Date: 03-Jul-2026
Our Ref: 2025/91211

Discharge of details reserved by conditions 6 (road specification), 7 (retaining walls), 8 (highway structures), 10 (noise assessment report), 17 (drainage strategy), 18 (surface water discharge), and 19 (storm events) on outline permission 2020/93777 for erection of residential development

**east of, Mill Lane, and Heaton Grange, Hanging Heaton, Batley, WF17 6EN
Application Number: 2025/91211**

Title: **PROPOSED DRAINAGE GA**

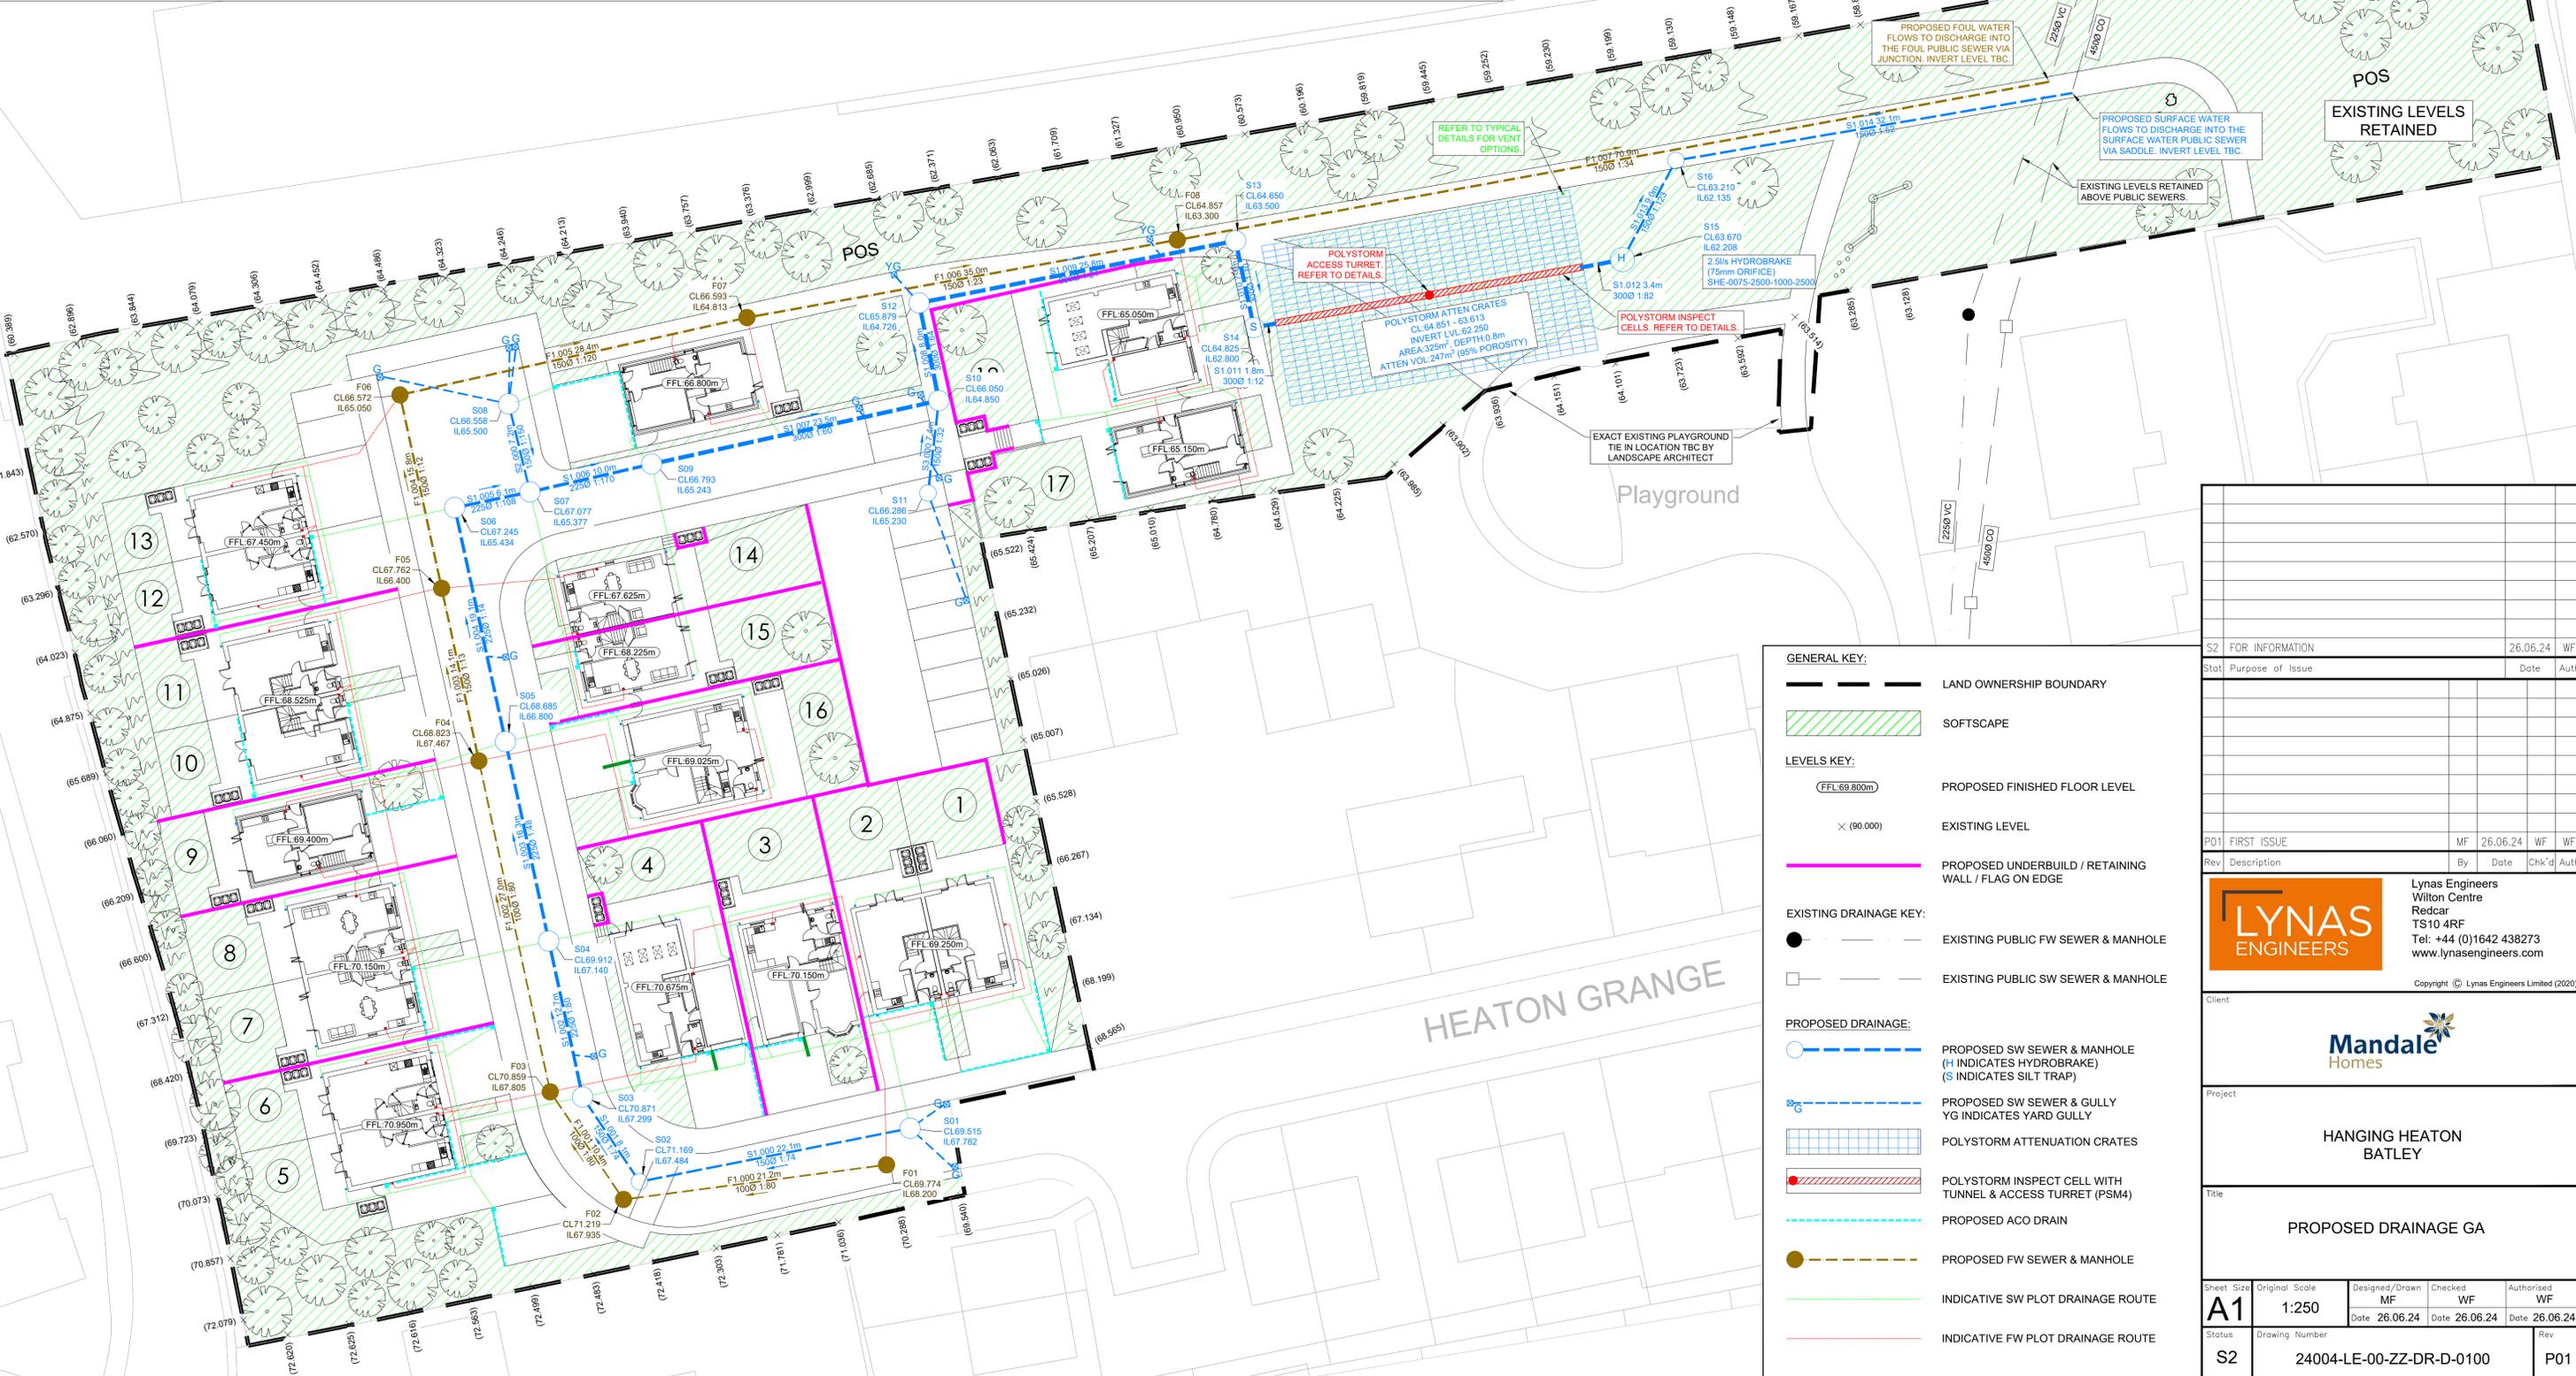
- *the silt trap MH upstream of the attenuation tank should be MH S10 rather than S14 (or both) as stated in the Drainage Strategy and detailed on the Typical Attenuation Tank Details drawing as this MH will be more easily accessible during desilting operations.*
- *Also, this MH should be clearly noted on the Proposed Drainage GA as a silt trap MH to ensure the Contractor installs the correct type.*
